Date: 09/10/2024

Re: **Floor Truss Repair Specifications**
Location: Lot 19 Tobacco Road (19 Looping Ct. Angier, NC)
JDS Project No.: RDU2409289
Date of Inspection: 09/10/24

MODEL: Magnolia D w/Brdm 4 - Floor

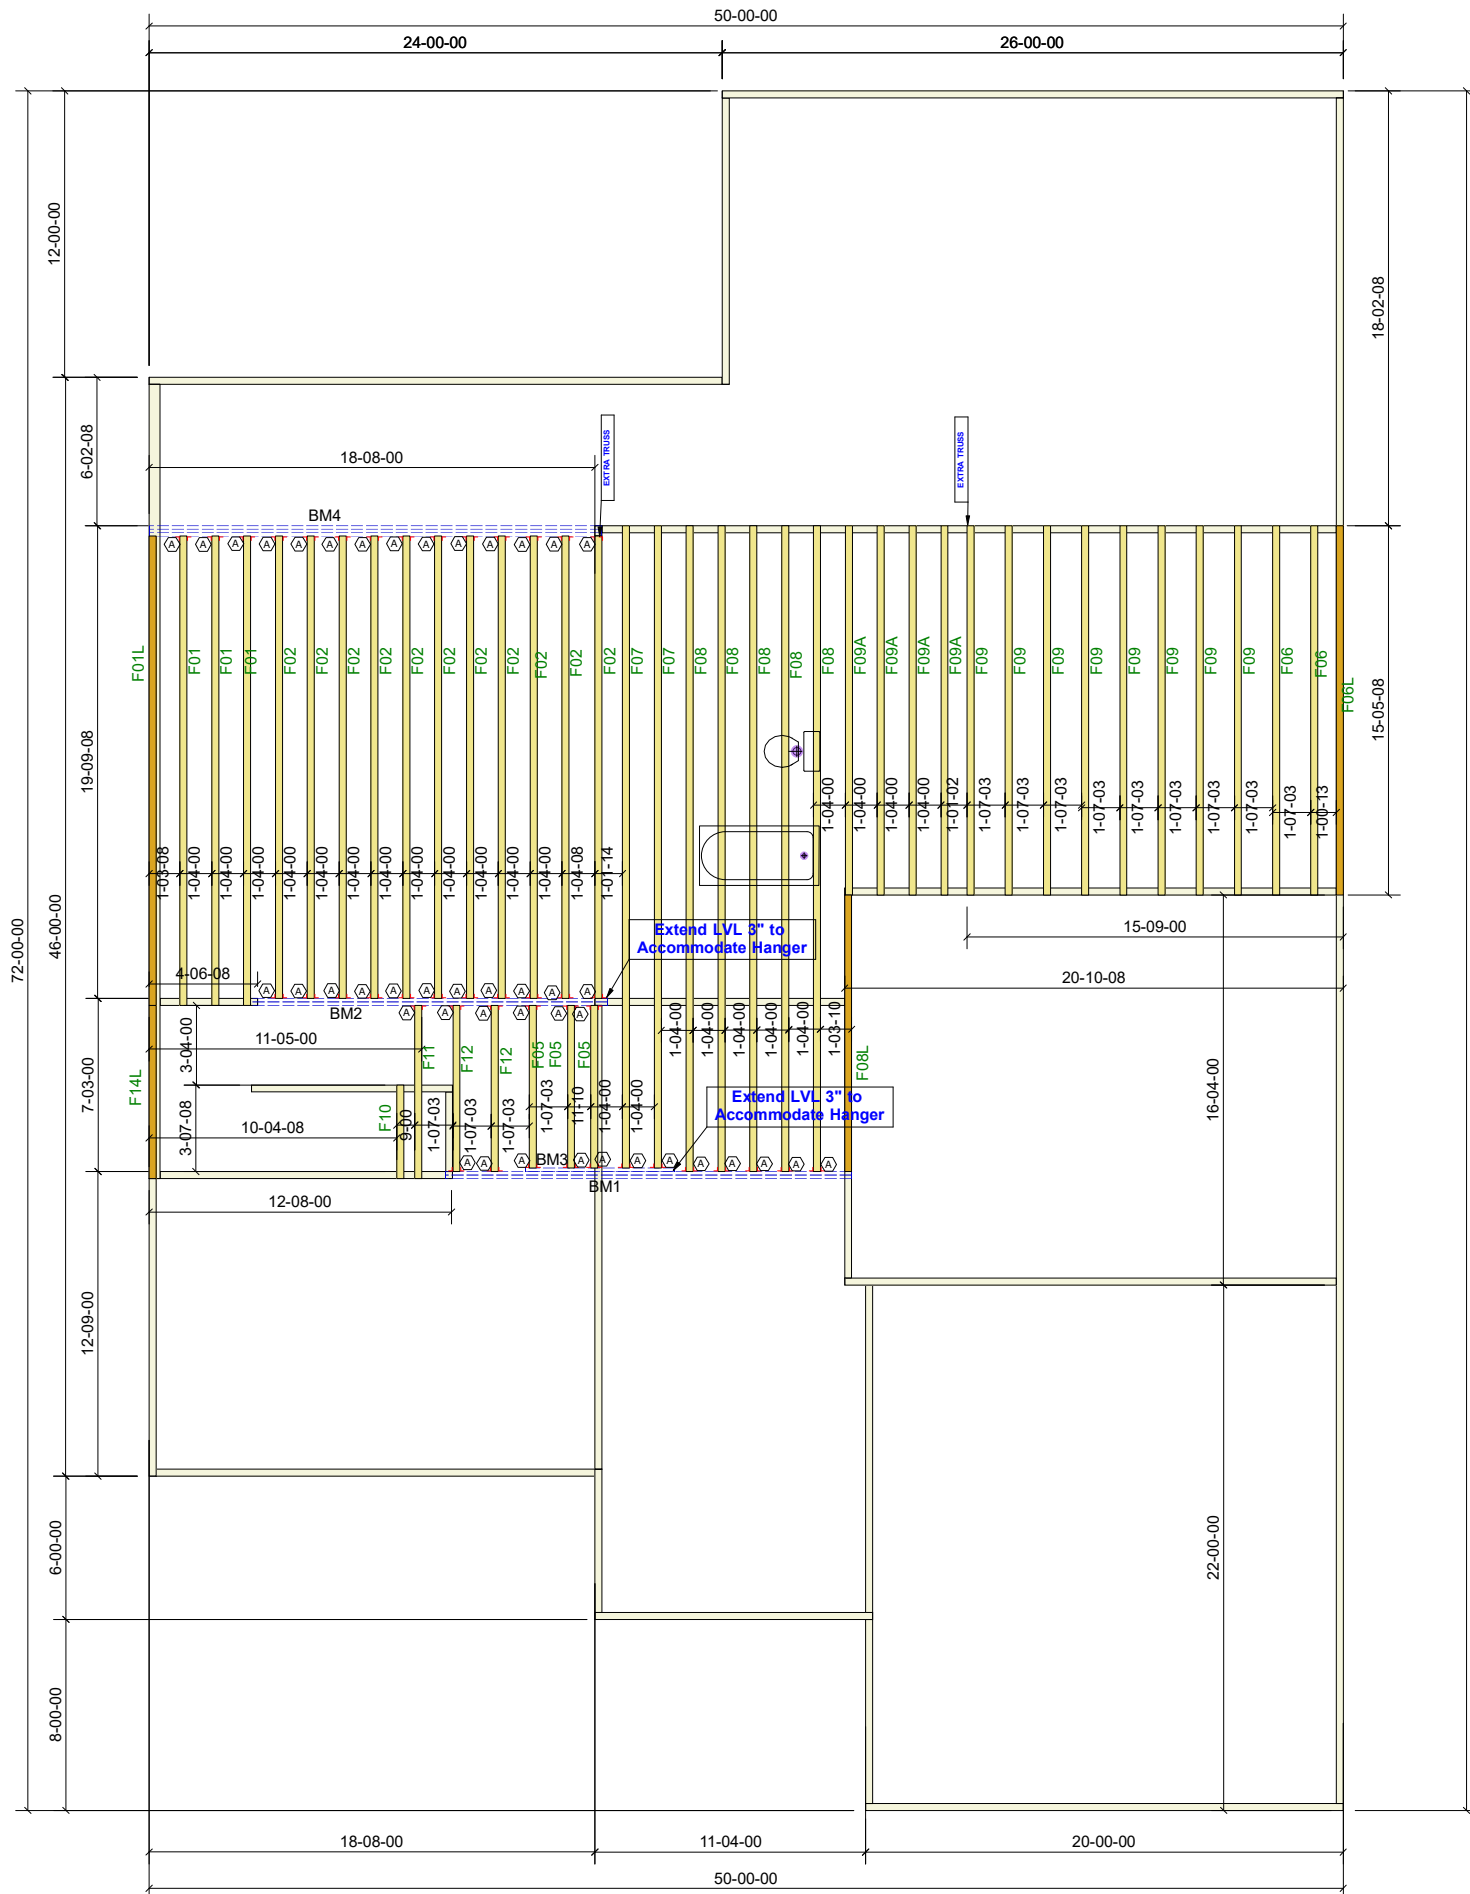
1. The 2nd left to right girder from the rear between the 2nd and 3rd front to back girders has multiple penetrations near the top.
2. The 11th left to right floor joist from the front wall between the 2nd and 3rd girder has penetration due to electrical wiring.

1. The penetrations do not compromise the structural integrity of the member, no further action is required.
2. The penetrations do not compromise the structural integrity of the member, no further action is required.
